Our Ref: EG/39/18/HH
Your Ref:

Town & Country Planning Act 1990 (as amended)
Town & country Planning (Development Management Procedure) (England) Order 2015
Application for Planning Permission for Works or Extension to a Dwelling

Development Ground floor rear extension
Location 2 The Cedars Barnham

Block Plan REV A

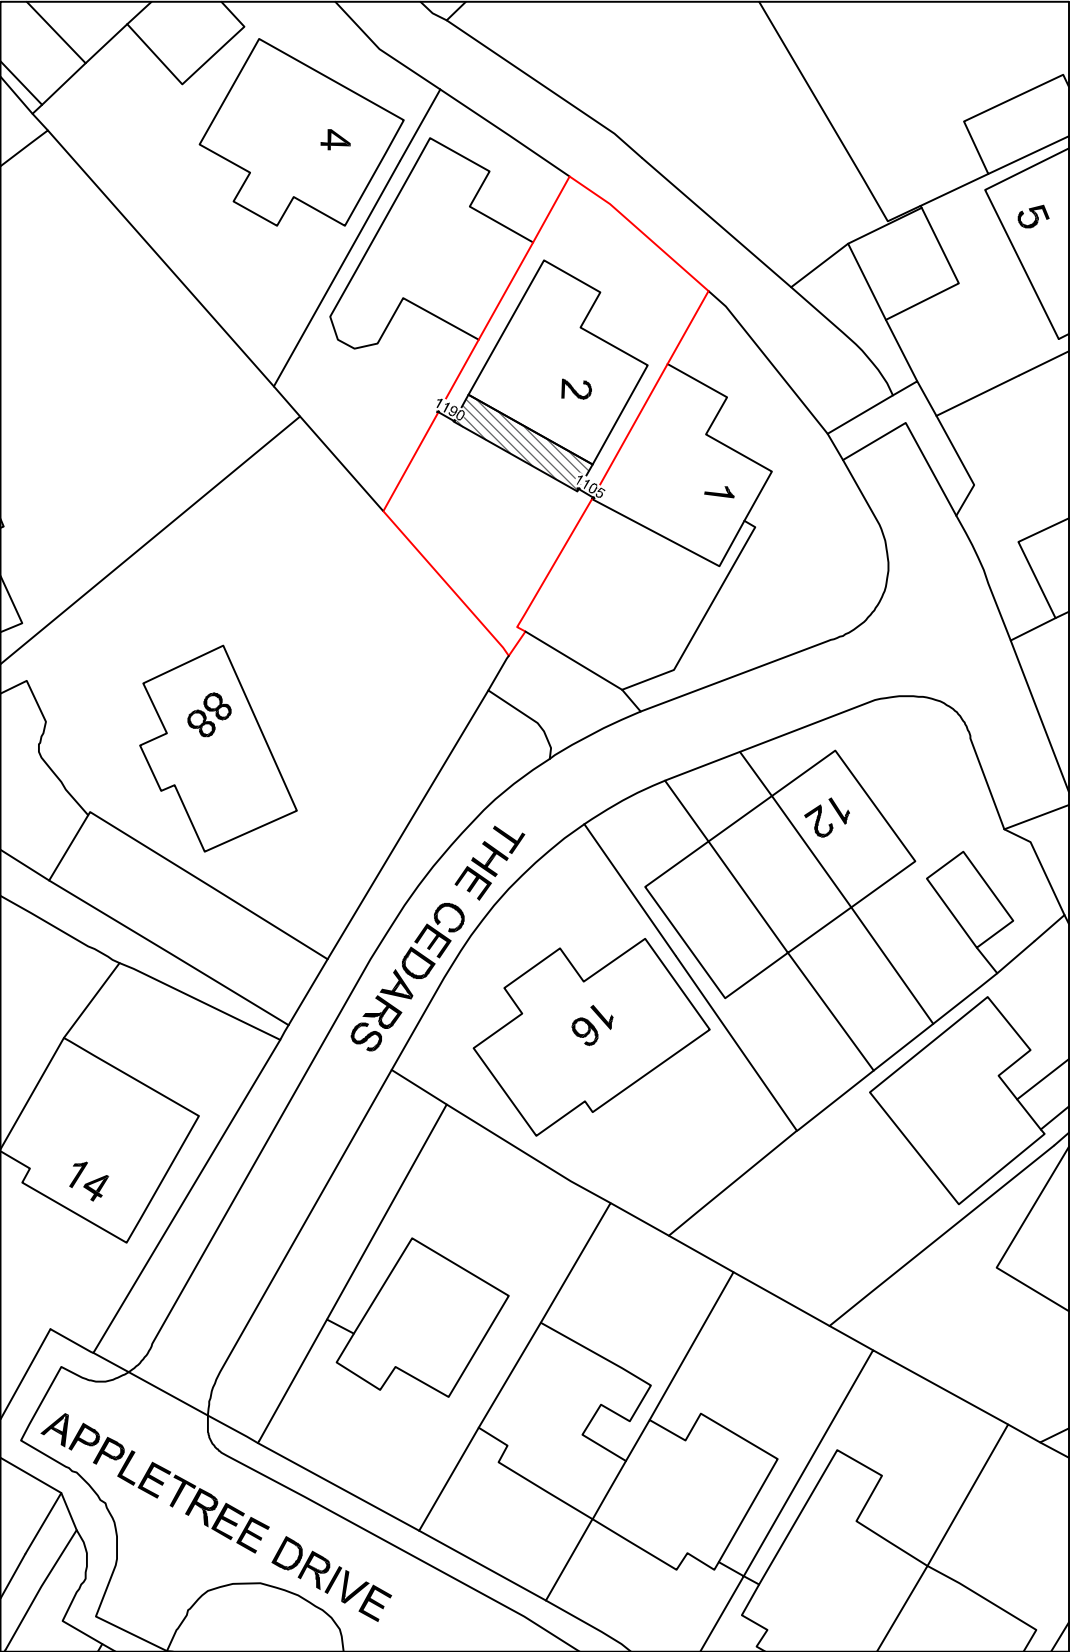
Block Plan Amend

Please submit 1 electronic or 3 paper copies of a block/site plan at a scale of 1:500 or 1:200. Further details of what must be included on the plan can be found in the National Validation Requirements. Please provide measurements from the proposal to the rear boundary.
